Our Ref: EP/3/20/PL

**Town & Country Planning Act 1990 (as amended)
Town and Country Planning (Development Management Procedure) (England) Order 2015
Application for Full Planning Permission**

Development Erect a cast iron column/post to match the existing lamp posts to attach CCTV
Location Village Green Sea Road East Preston

4m, Base Hinged Gainsborough  
Column c/w Size 2 Victoria Lantern

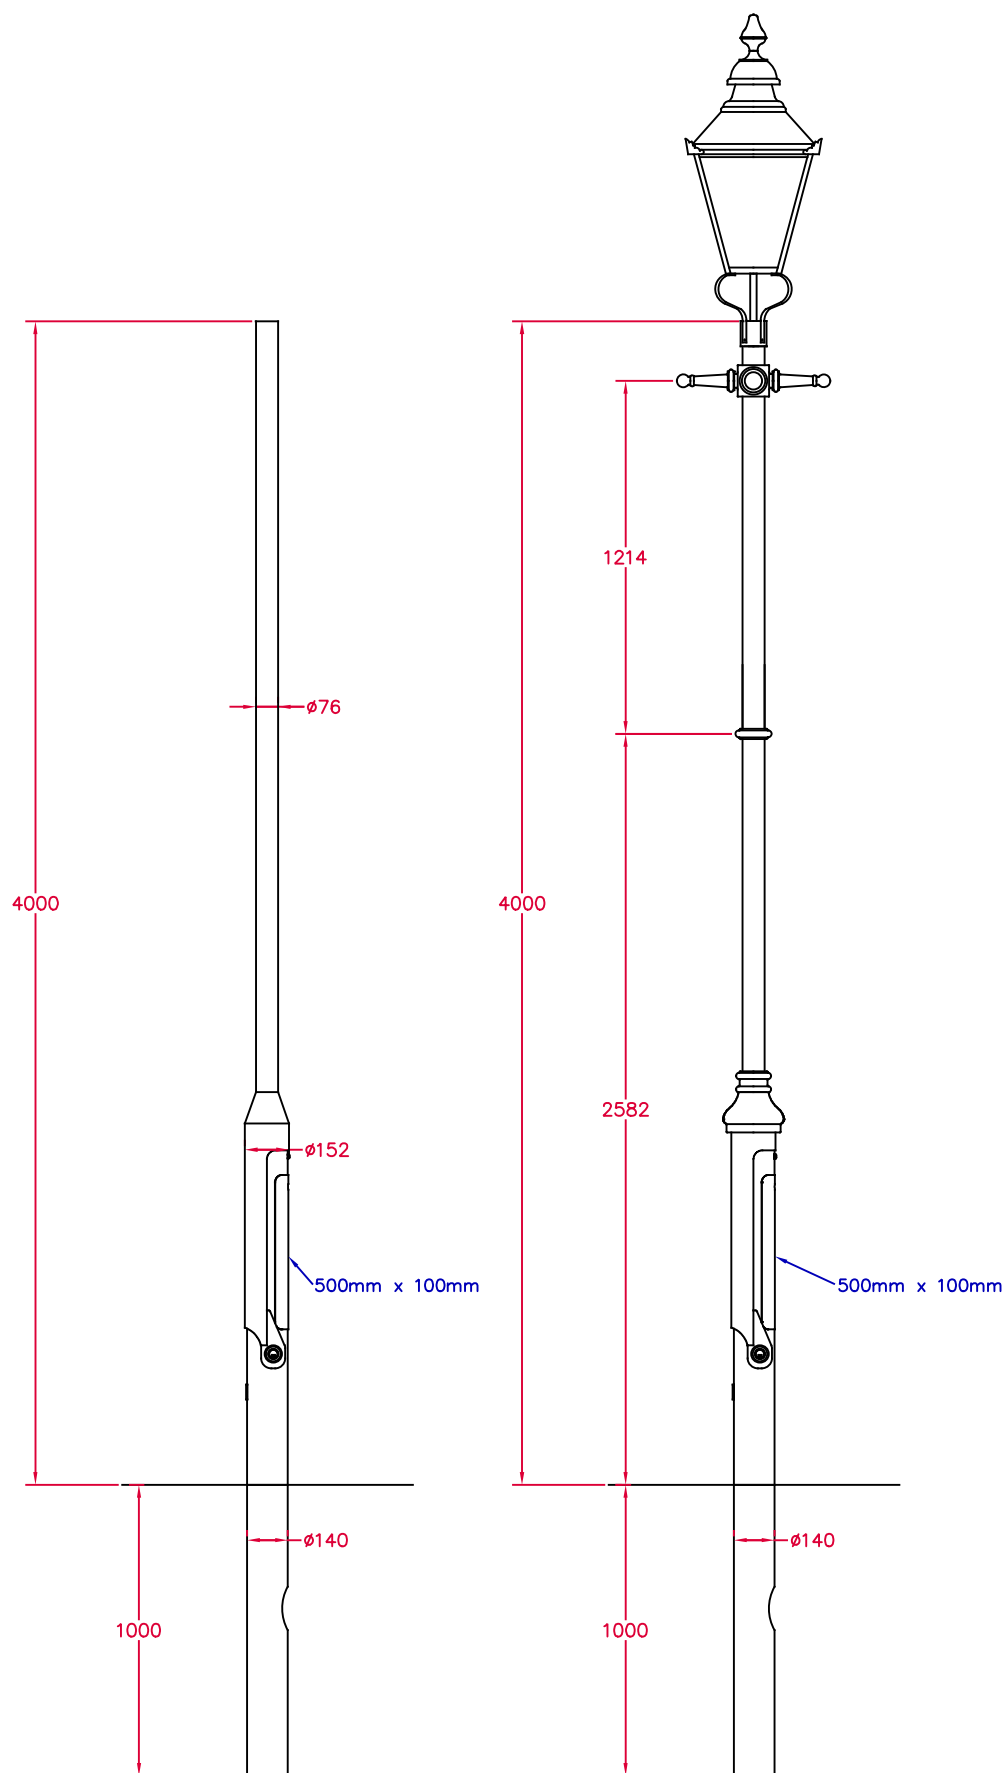
Please provide amended drawing/photos (to scale or with clear metric measurements) of the proposed post along with details of the CCTV.
